EPC STORMWATER REVIEW COMMENTS
IN ORANGE BOXES WITH BLACK TEXT

APEX WASTE SOLUTIONS GRADING AND EROSION CONTROL PLANS COUNTY OF EL PASO, STATE OF COLORADO OCTOBER 2024

PCD FILE NO: PPR2441

SHEET # **G.2**

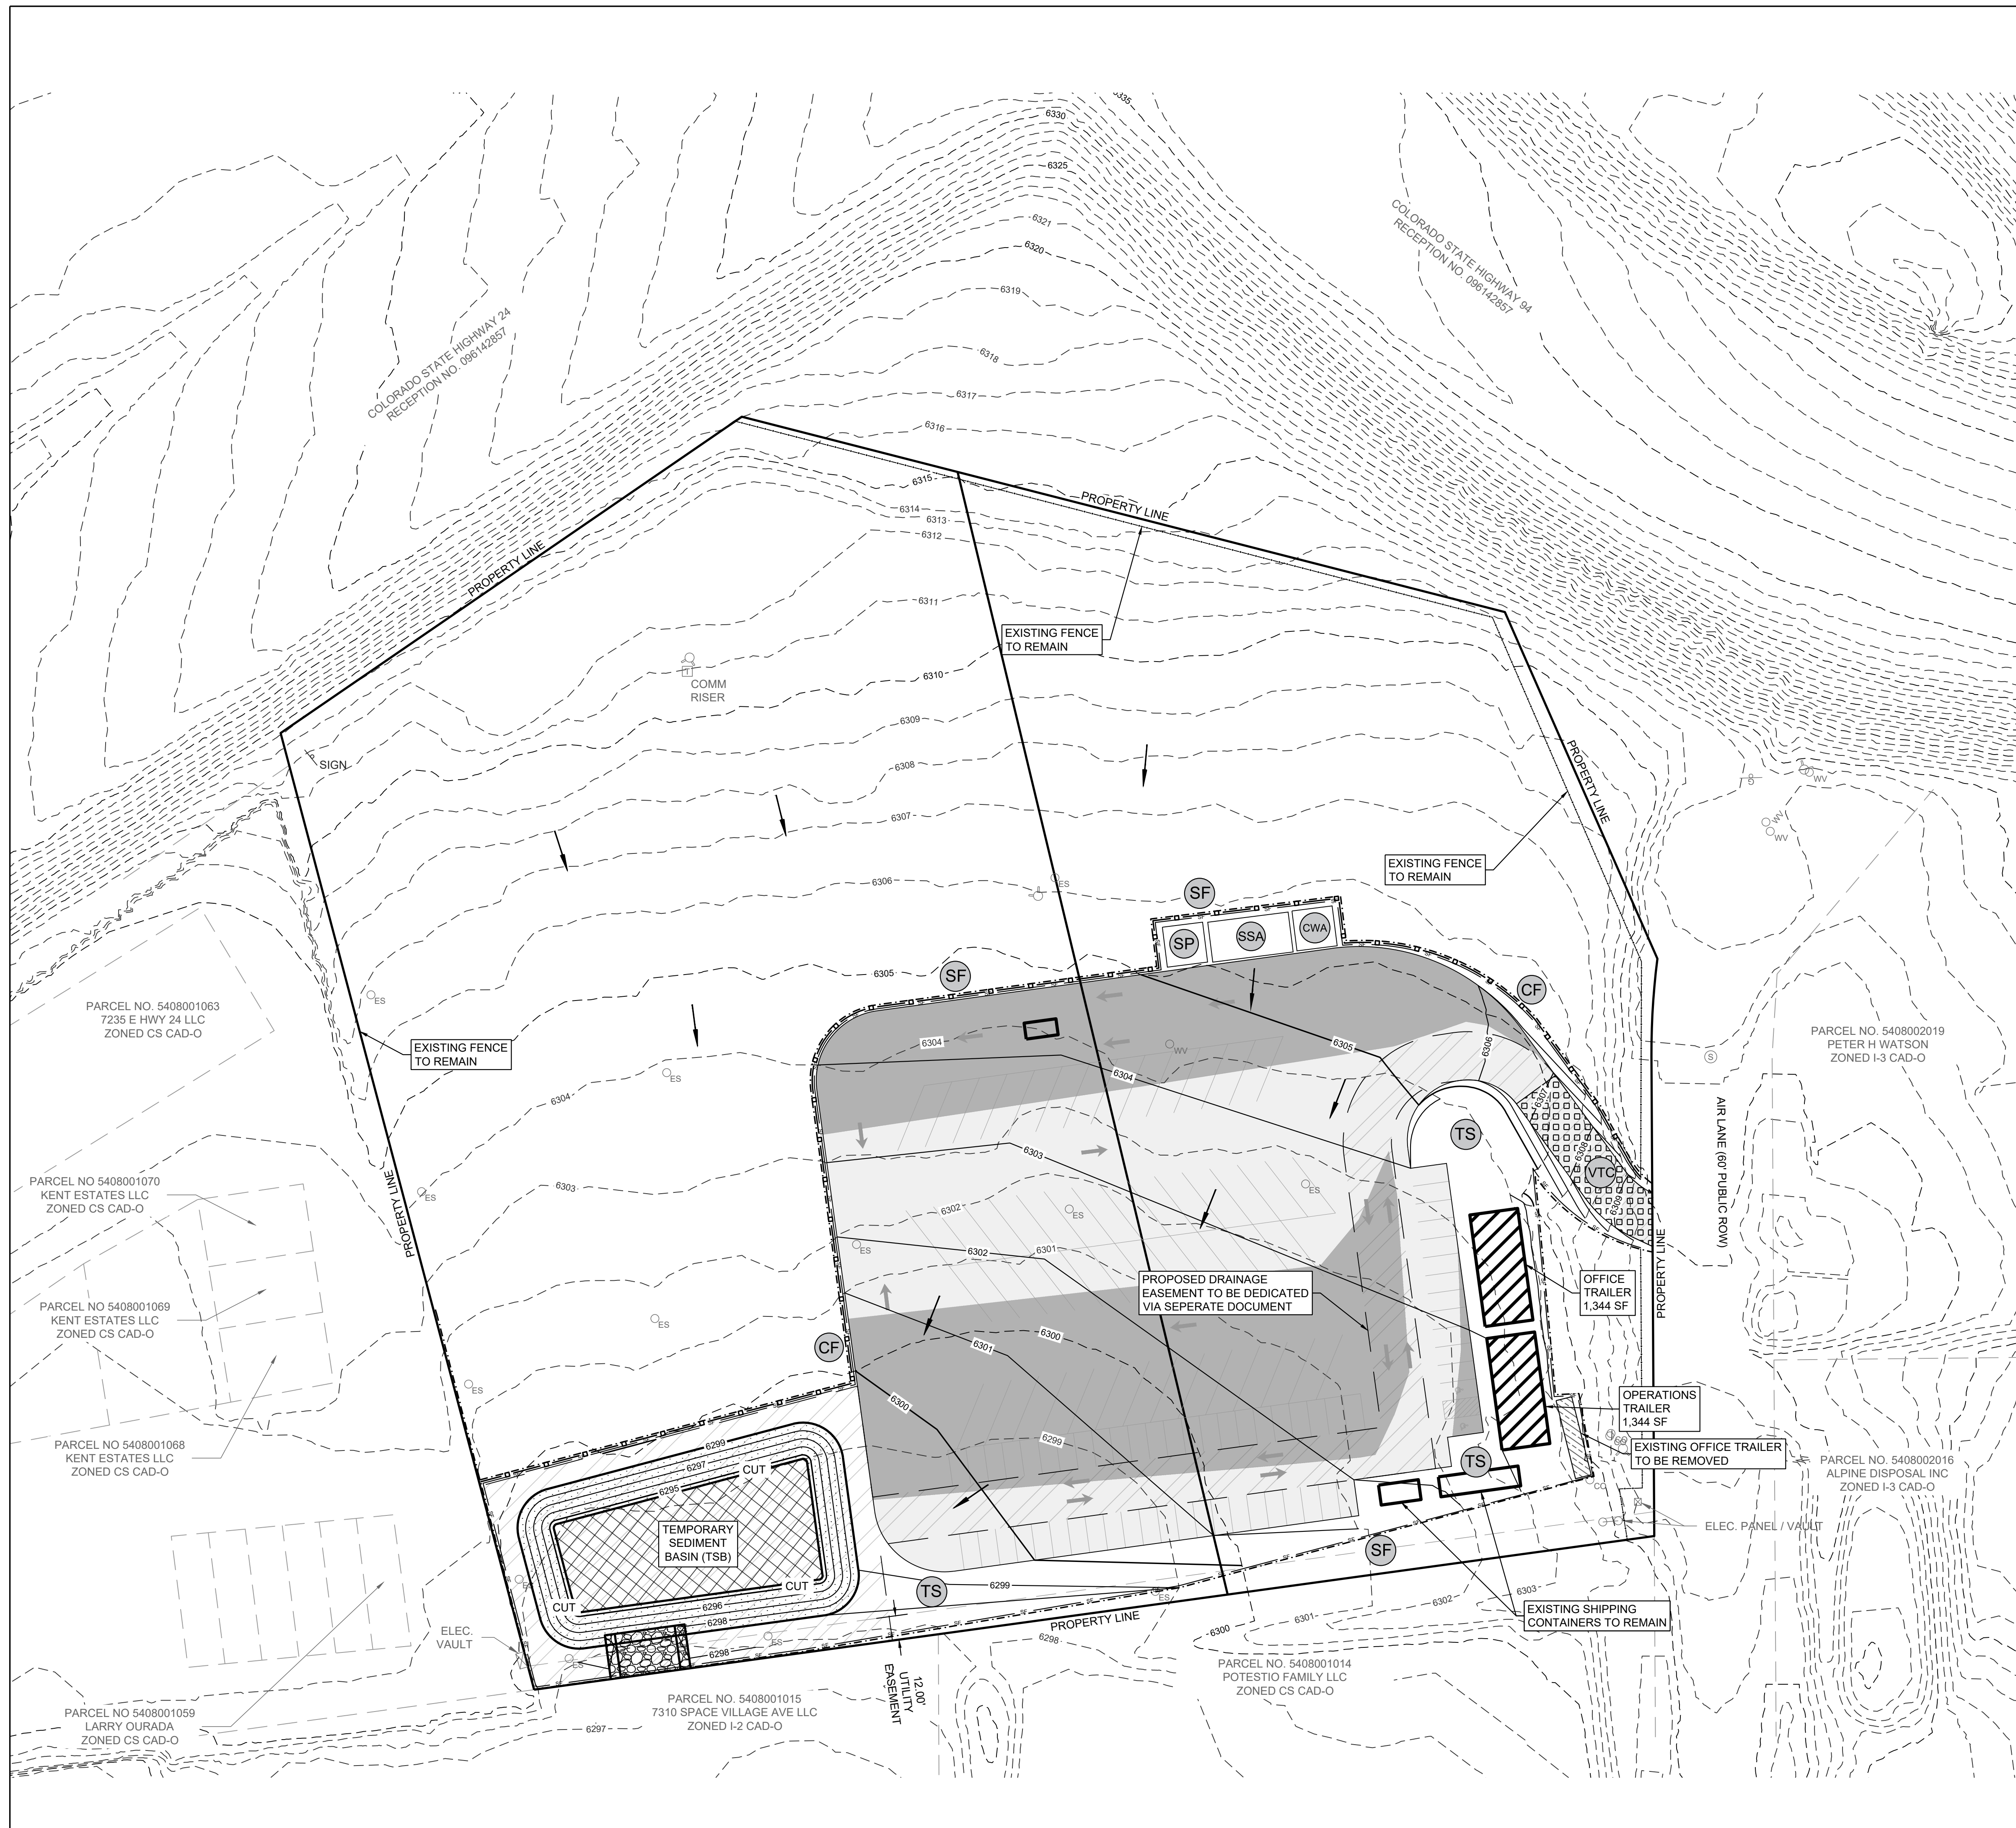
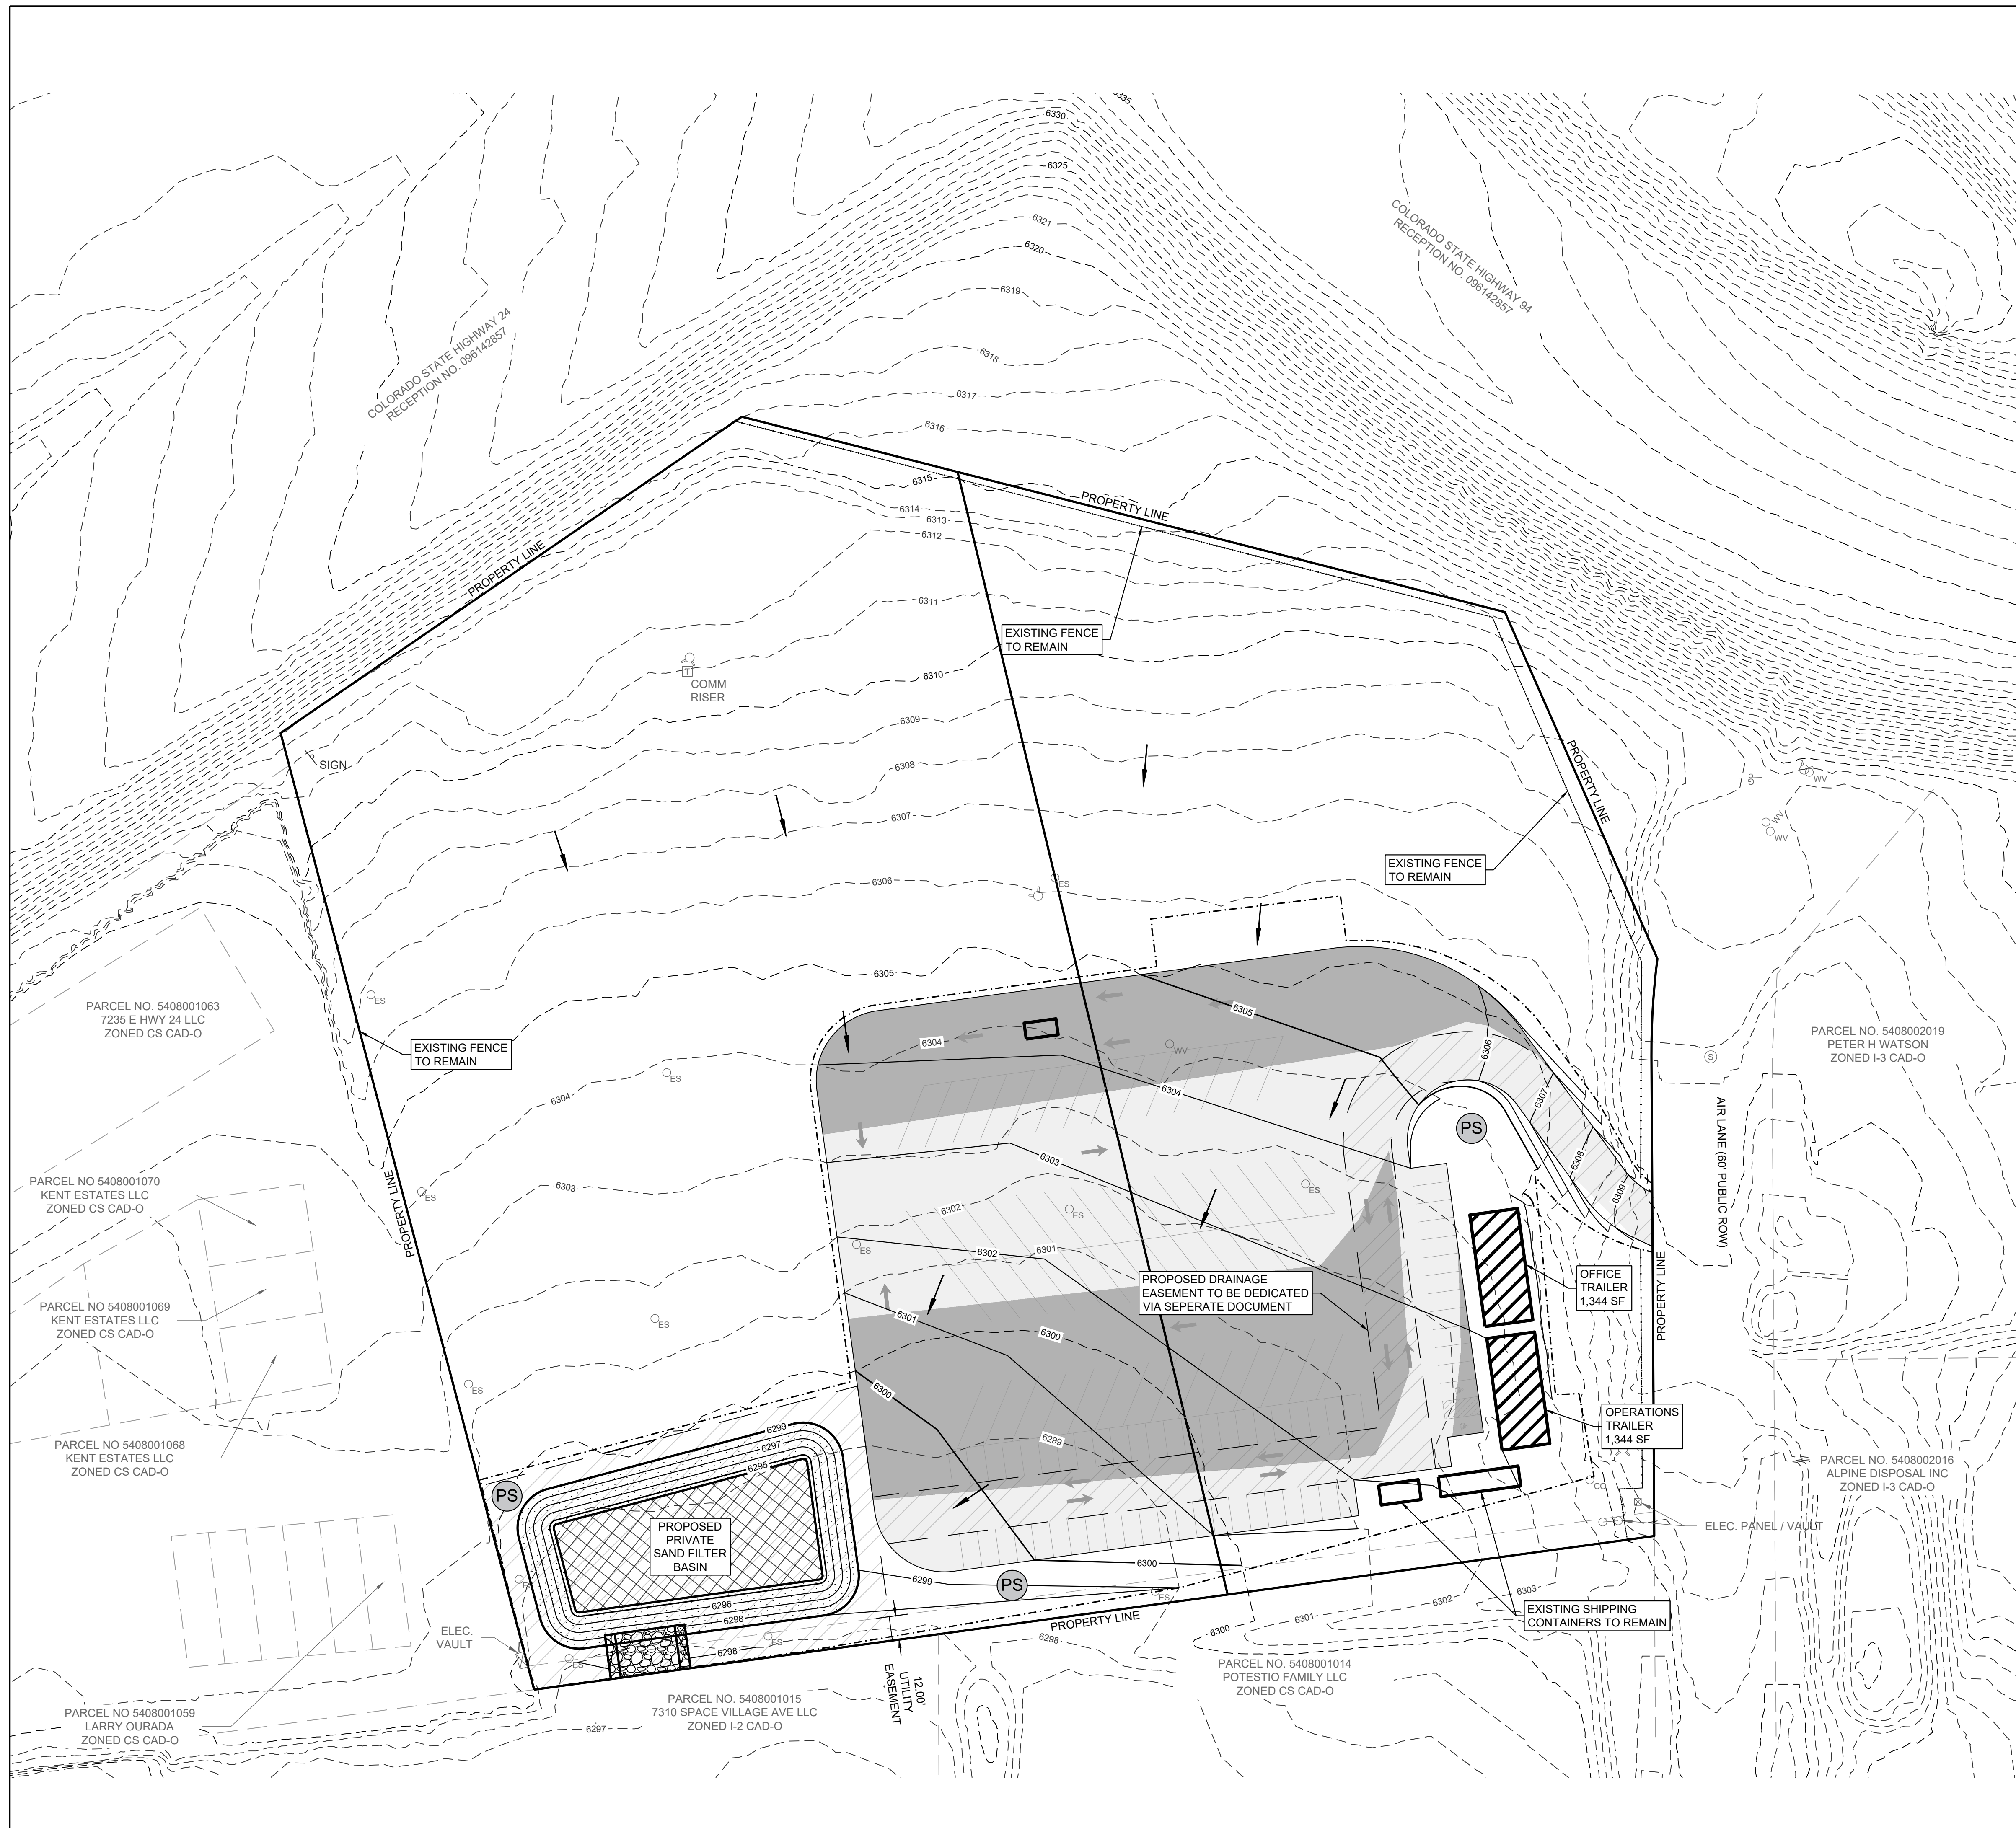
GEC Checklist Items H and M. If "limits of disturbance" and "construction boundary" are the same, change to "limits of construction/disturbance" or otherwise show as separate line types for each on the legend and figure.

GEC Checklist Item v - Label all proposed temporary construction BMPs by phase of implementation for this sheet clearly identify what is initial and what is interim.

GEC Checklist Item p - identify all areas of cut and fill.

Show how the proposed contours/grading of the TSB tie into the existing contours.
